**By e-mail only:**Your reference: 21/02337/DISC, 21/02339/REM

**Land off Middleton Stoney Road, Bicester (“Himley Village”)**

I refer to the submission recently made as referenced above to the Council as Local Planning Authority, relating to the discharge of a number of Conditions across the whole of the site consented in outline under the reference 14/02121/OUT.

TITLE
**S278 OFFSITE HIGHWAY WORKS
SPINE ROAD ACCESS
GENERAL ARRANGEMENT
SHEET 1**

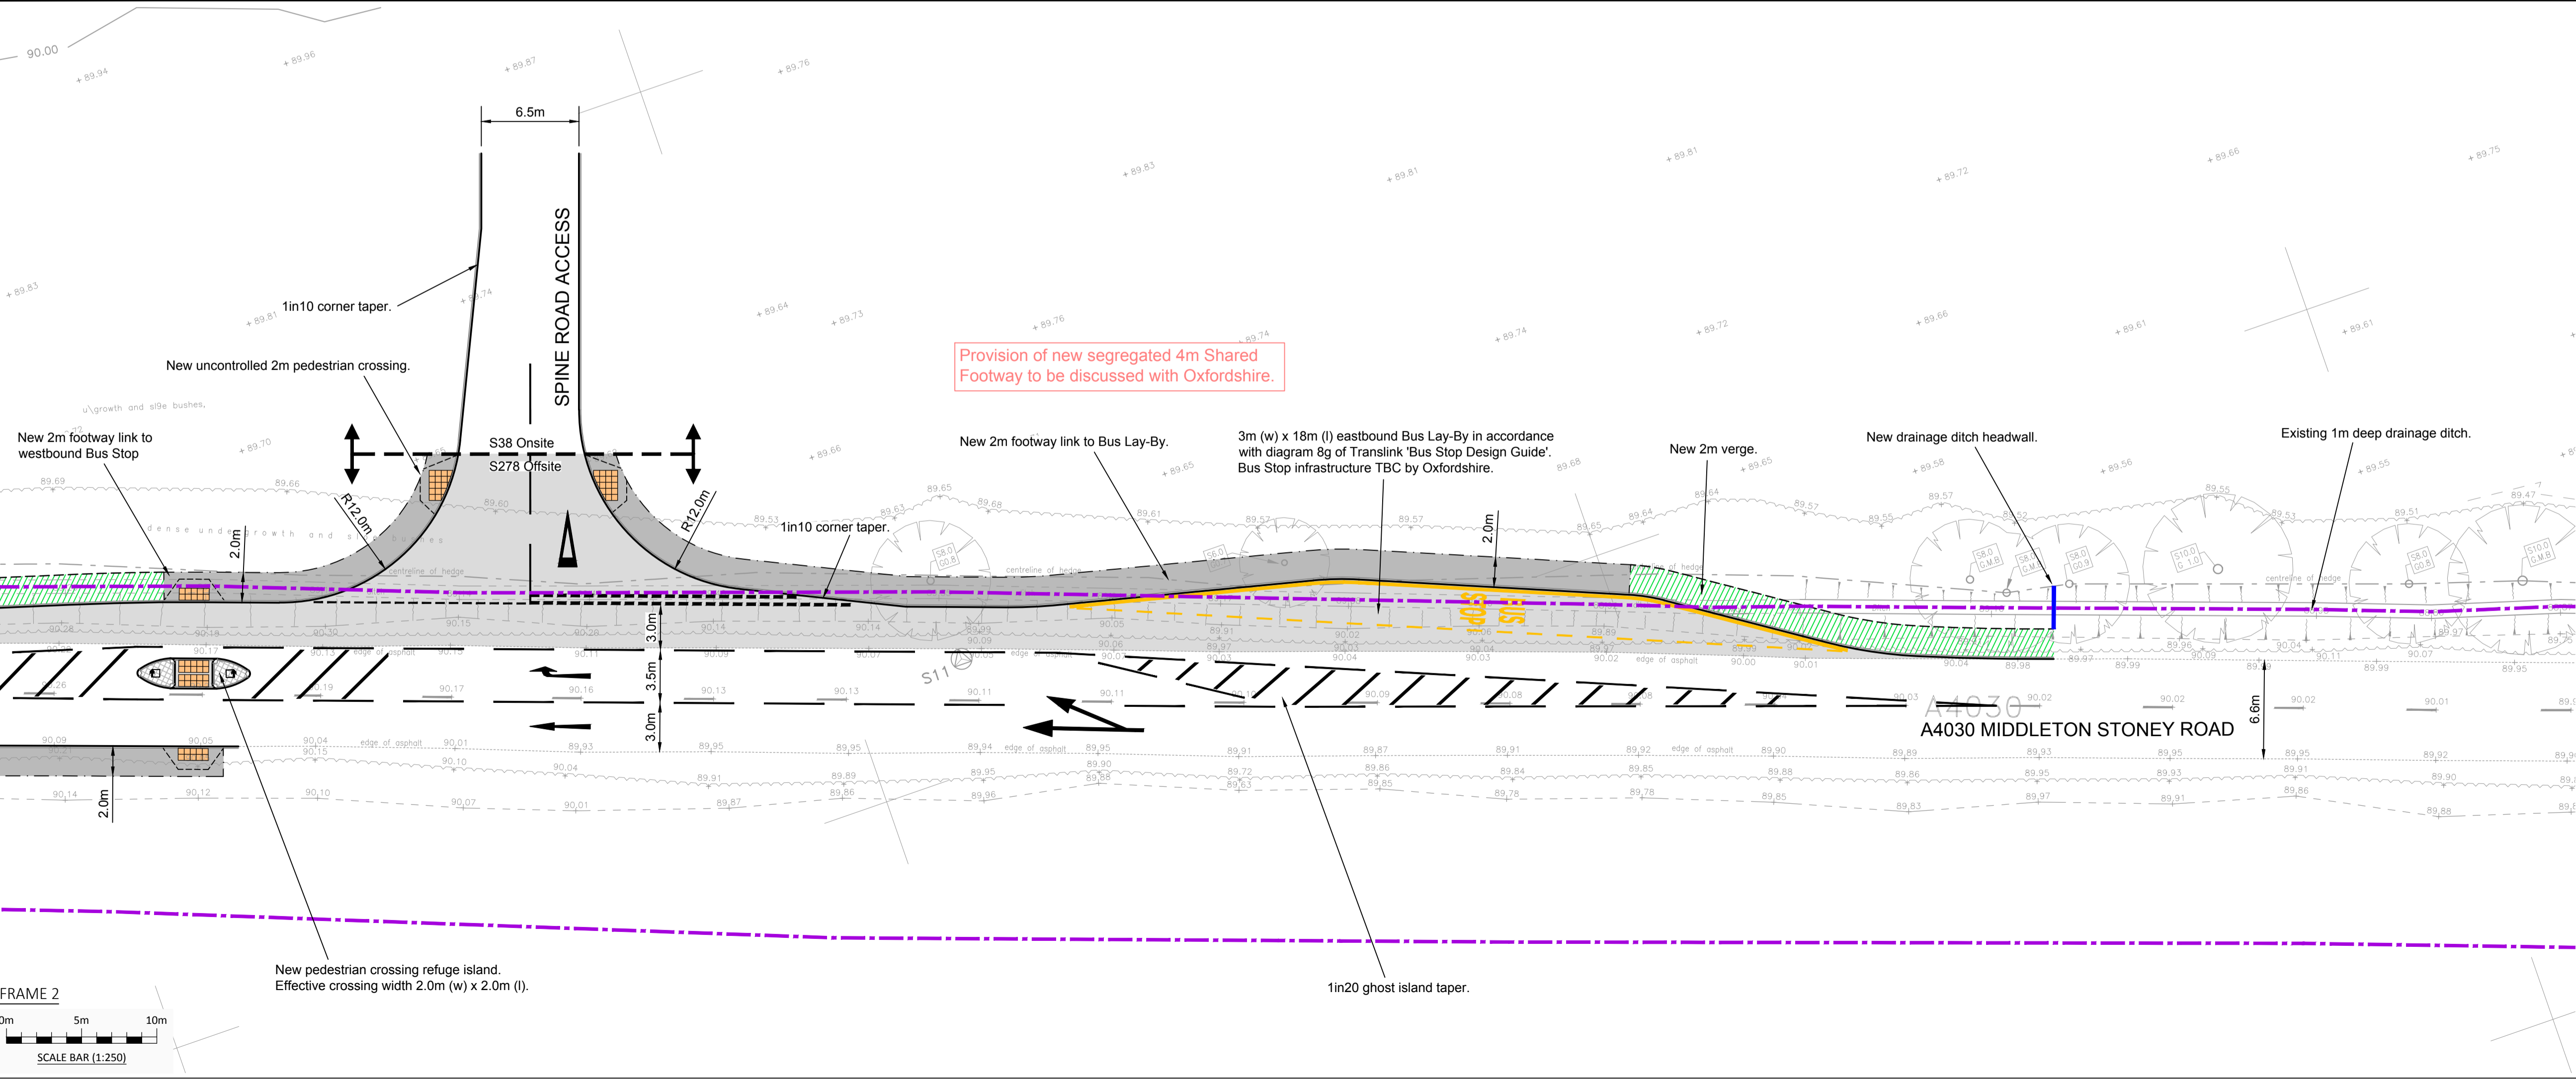
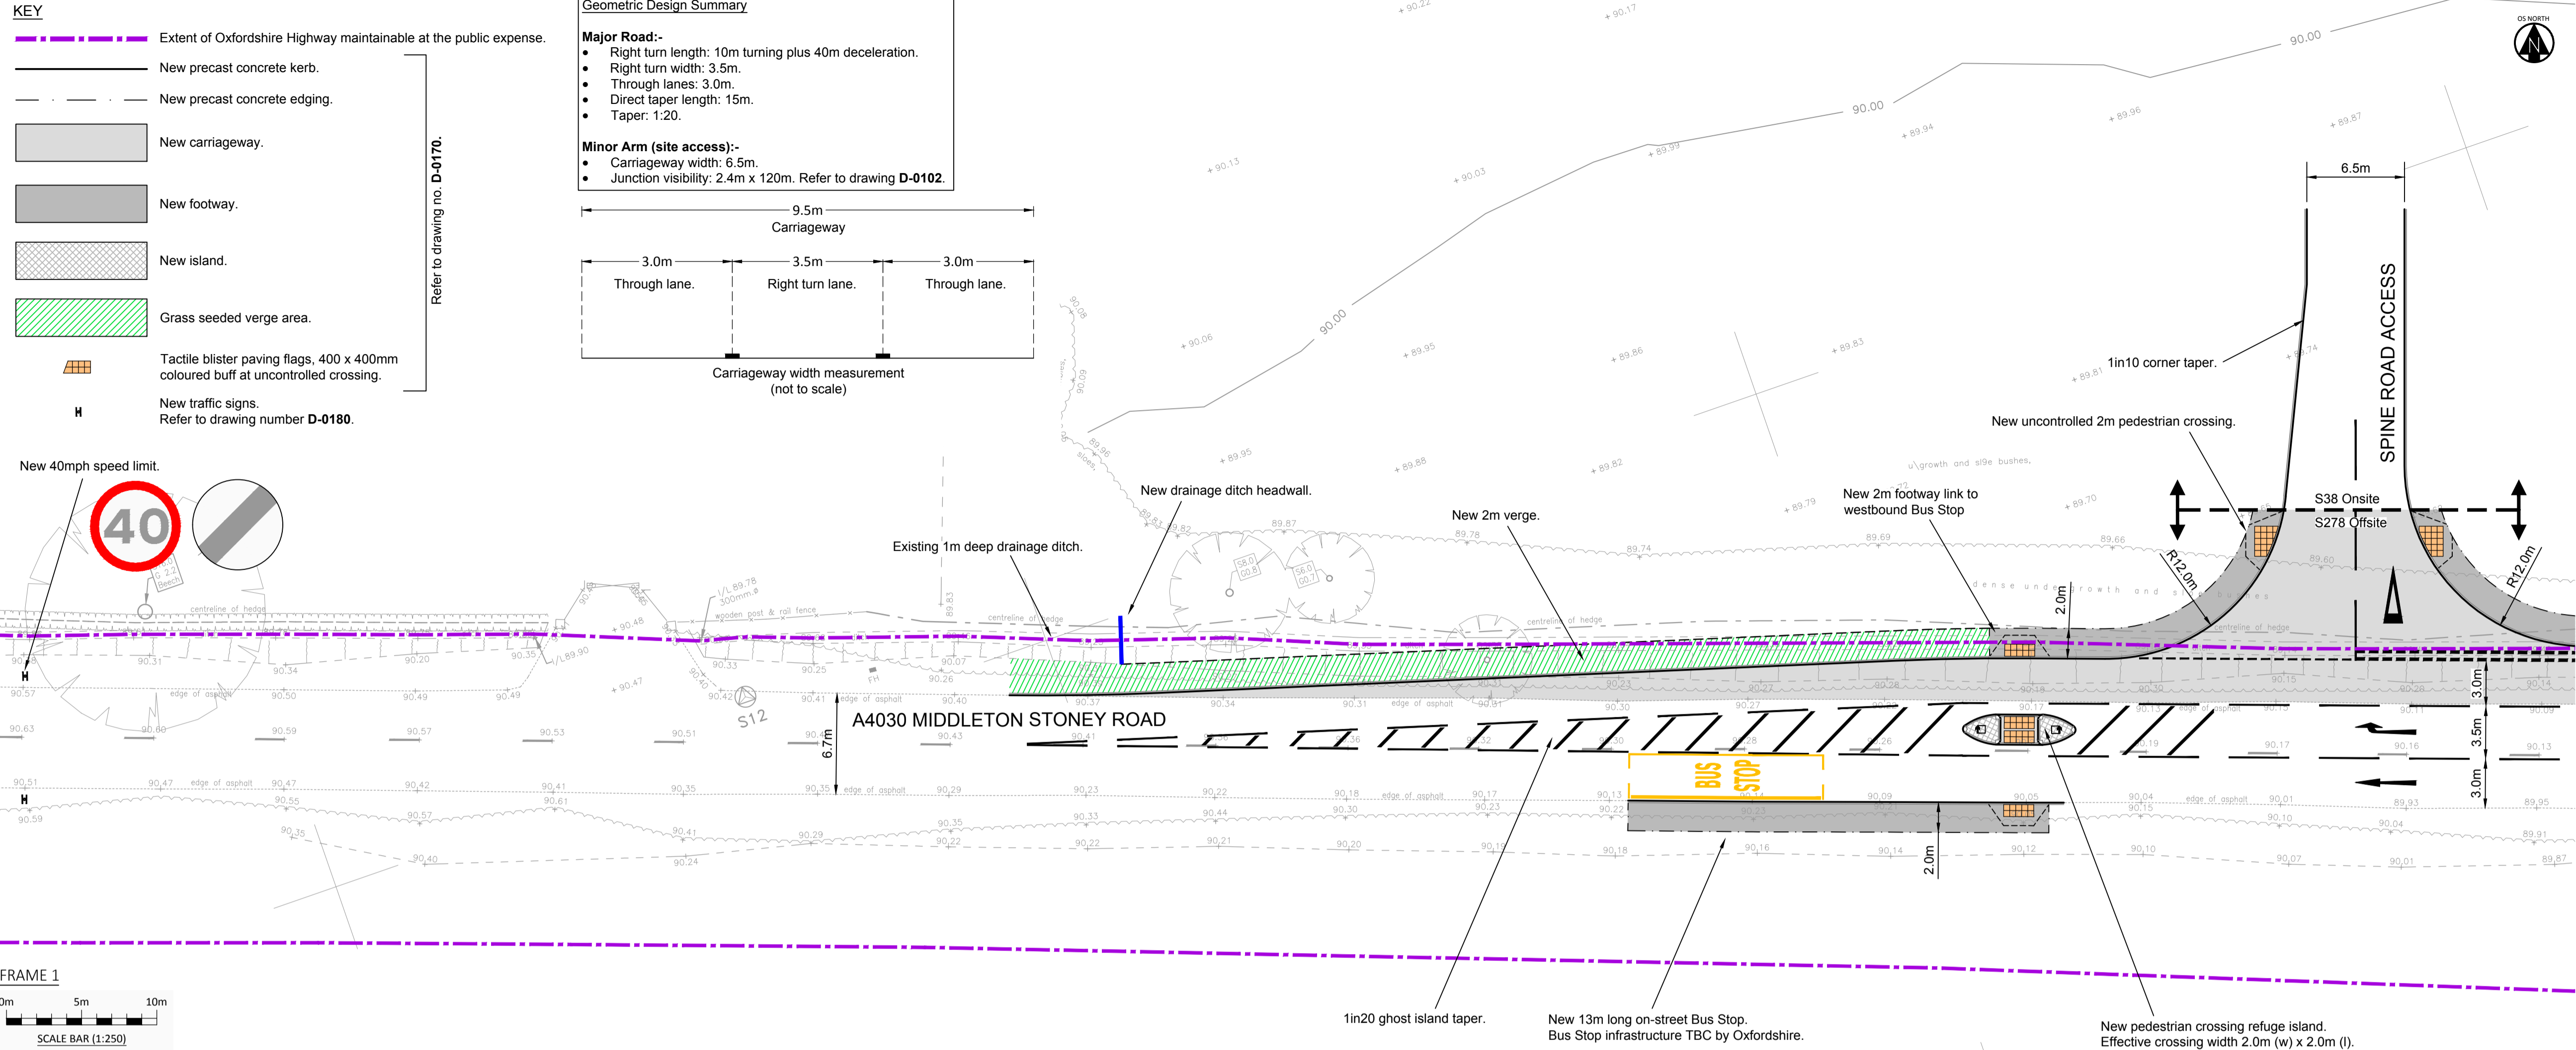
The only bus stop provision explicitly made at any point in the submissions is a single new pair on Middleton Stoney Road. This is neither adequate, convenient nor attractive. It is a minimalist offer for what today is a service of very

limited relevance. However, this provision is important to provide some kind of choice for the very first occupiers, as it clearly would be infeasible to bring any service into the site for some time, until the interim on-site bus route is constructed and open for public use.

To offer scope for a bus service or services being provided in the most flexible possible manner, we would recommend a third stop on the access arm into the site, down-stream of the junction. This will serve the mixed-use area, complementing the currently proposed provision on Middleton Stoney Road. Such an arrangement is good practice and has been implemented elsewhere in the County, for example at Crab Hill, Wantage, and at Curbridge Meadows, West Witney.
